WEST SUSSEX COUNTY COUNCIL CONSULTATION

TO:	Arun District Council Ross Leal	
FROM:	Debbie Farrell WSCC County Highways	
DATE:	14/3/18	
SUBJECT:	FG/33/18/PL Demolition of polytunnels, use of land for Class B8 container self-storage & the siting of 42 No. single-stacked storage containers, an office/toilet portacabin, new fencing, gates, CCTV, lighting & alterations to the entrance. Land at former McIntyre Nursery, Littlehampton Road, Ferring, BN12 6PG	
DATE OF SITE VISIT:		
RECOMMENDATION:	☐ Advice ☐ Objection ☐ Modification ☒ No Objection ☒ More Information ☐ Refusal	
S106 CONTRIBUTION TOTAL:	TBC

TITLE PROPOSED SITE & BLOCK PLAN	DWG NO 5285-2	REV C
--	-------------------------	-----------------

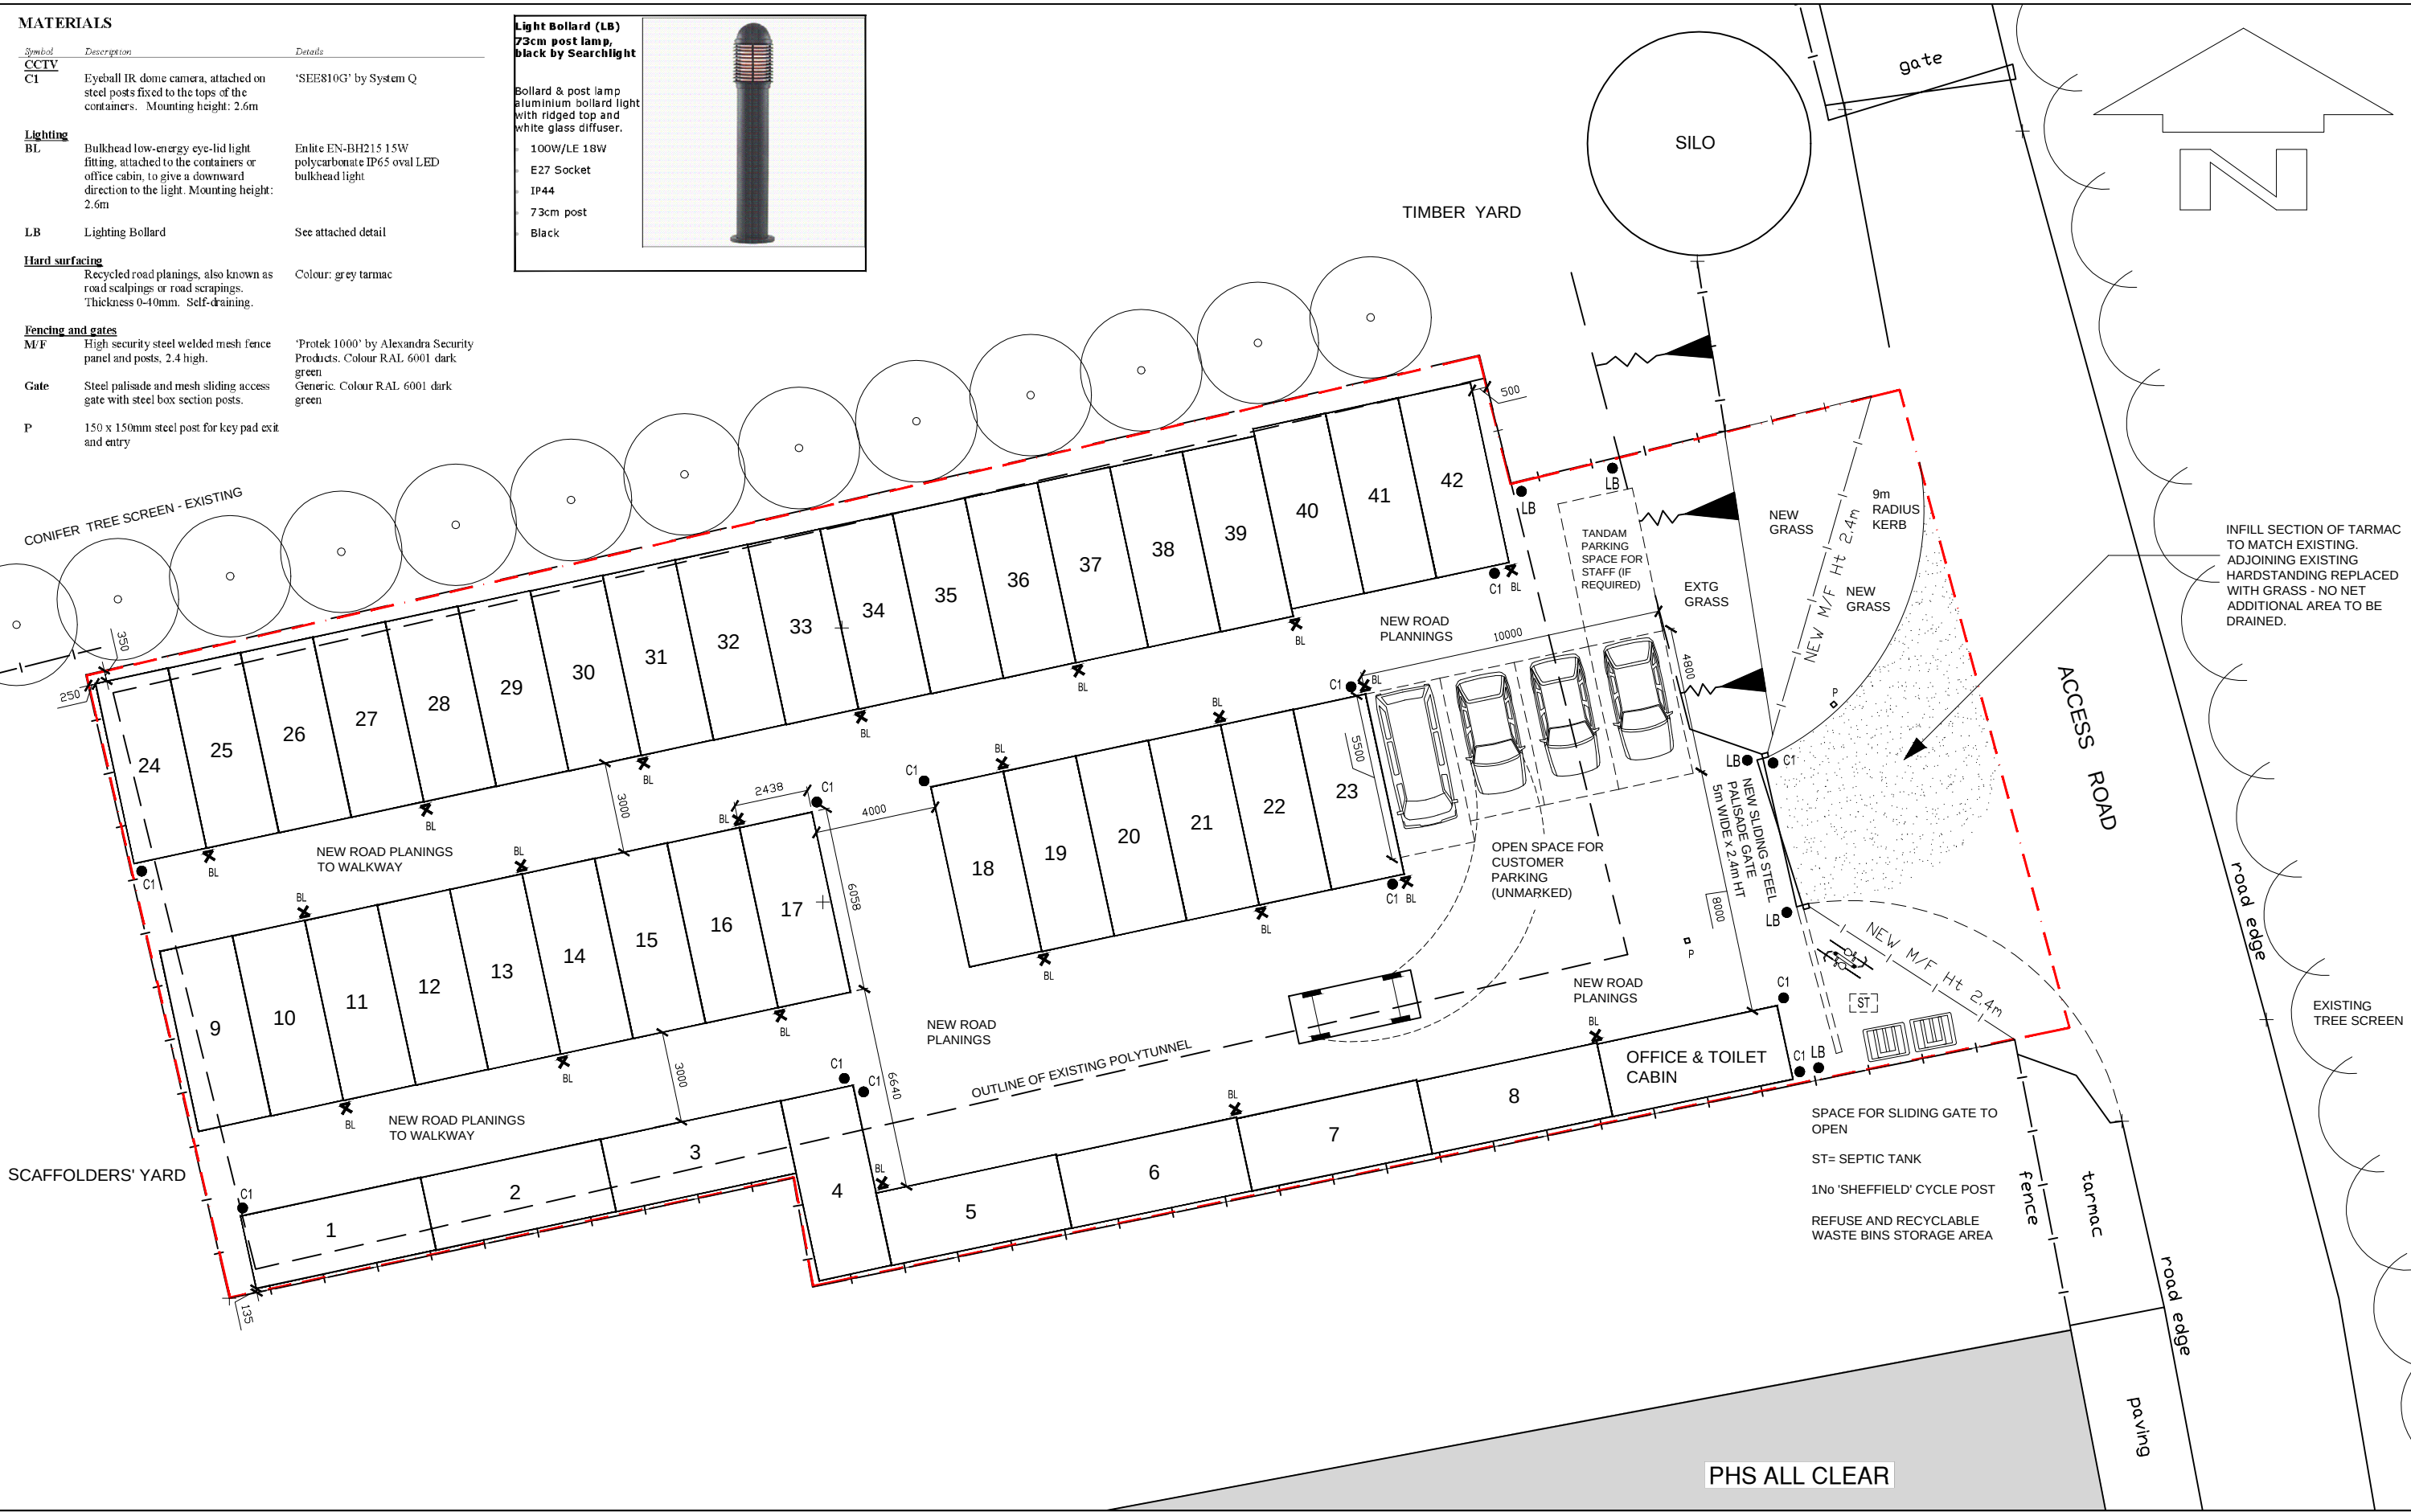
No information has been provided on how the containers will be delivered/removed from the site ie on what sort of vehicle. It is advised that

the applicant consider this to ensure there is sufficient room for large vehicles to turn into the site (from the public highway) and exit safely without impacting on the public highway. Can the applicant please provide details of how the containers will be delivered and a plan showing swept paths of the delivery vehicle manoeuvring into and out of the access with the A259. Consideration of how a large vehicle will manoeuvre within the site in order to re-enter the site in a forward gear is also required.
